EPC STORMWATER REVIEW COMMENTS
IN ORANGE BOXES WITH BLACK TEXT

July 12, 2022

RE: Winsome Filing No 1 – Detention Pond Certification

Winsome Filing 1
Pond D Asbuilt 11-08-21

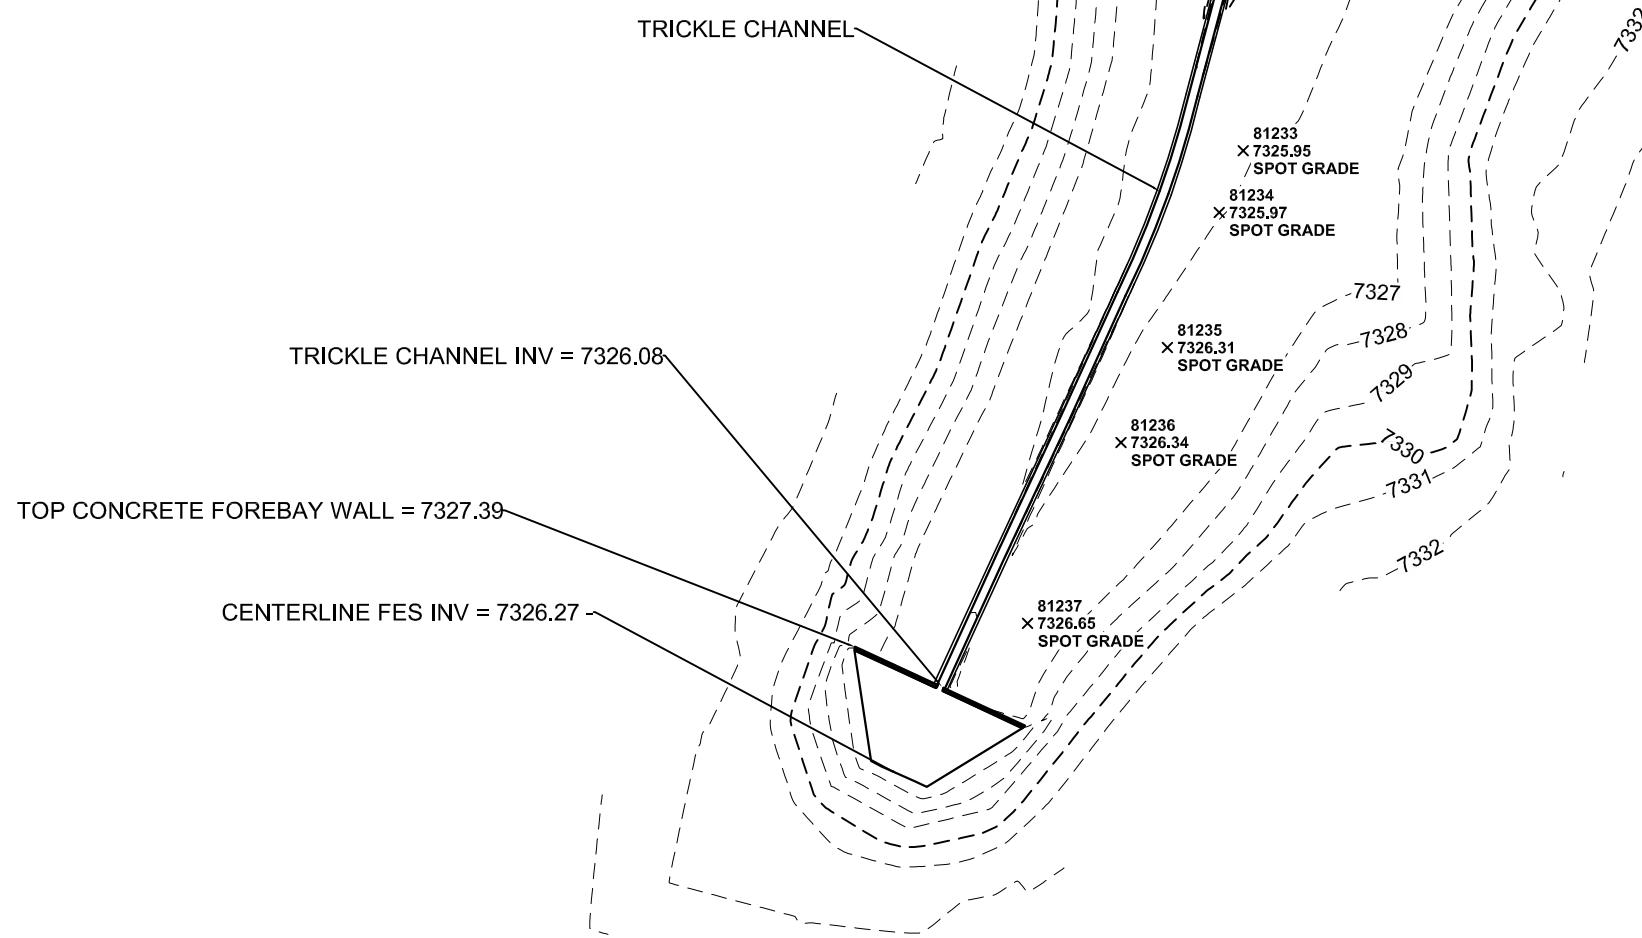
Pond D is not meeting the required and approved drain times. The WQCV needs to drain in 40 hours.

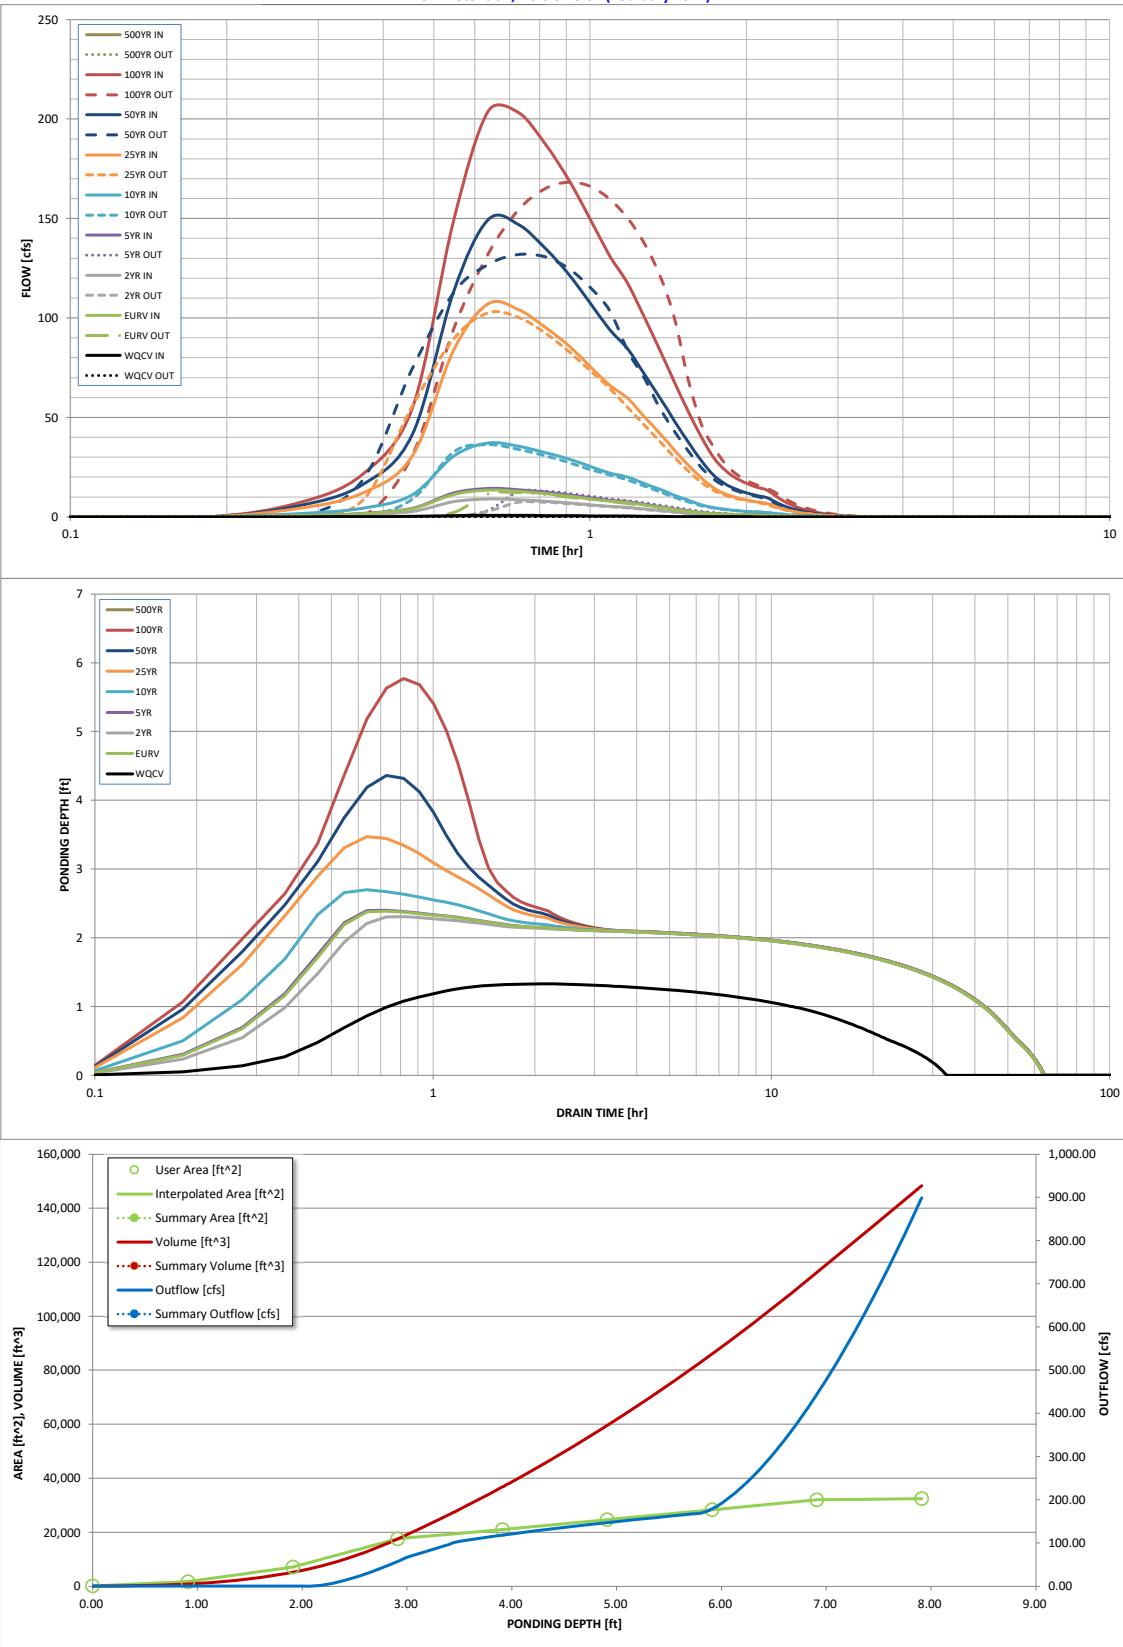
The pond does not meet the 40 hour drain time requirements for the WQCV. The approved drainage report shows a drain time of 44 and 47. The pond needs to meet the required drain times.
